Consultation on planning application, 3/2024/0782, Barn at Lower Hud Lee Farm Longridge Road
Hurst Green BB7 9QW

The parish council wish to raise an objection to this planning application, the reasons for which are outlined below.

EXISTING ELEVATIONS

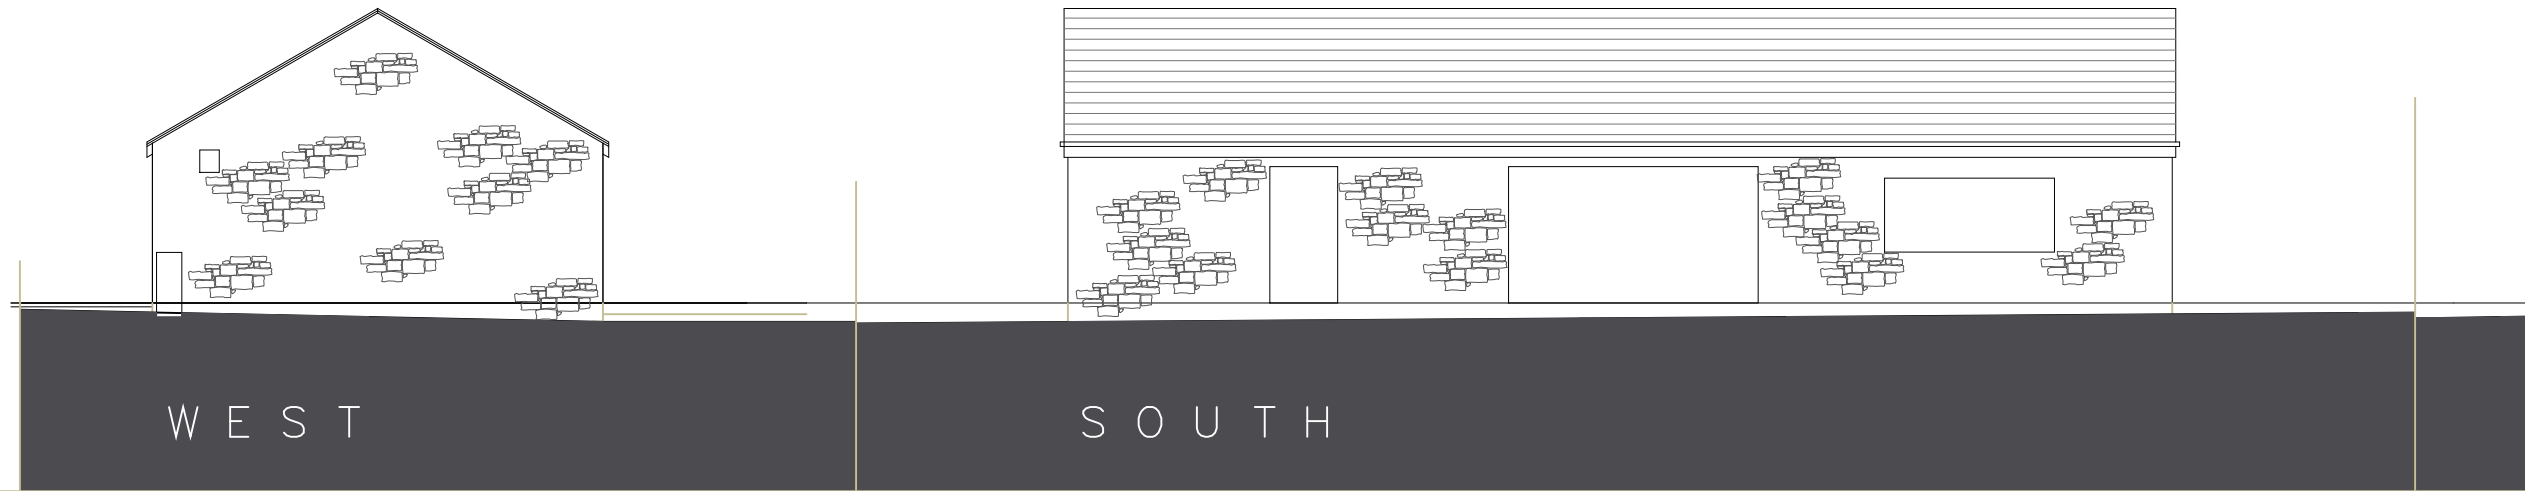
1. The Parish Council oppose this application.
2. The plans and elevations submitted are inaccurate: they show the building with the work that has already been carried out, not the existing small farm buildings. One half was in stone, one half in brick - please see the attached sale catalogue dated February 2023, which has a photograph of the existing stone and brick outbuildings, and refers to them as such in the description of Lot 2. Since then, the brick section has been demolished, new stonework built, new openings made, and the footprint extended. It is described as a redundant barn, however the plans show a new structure, not the original.
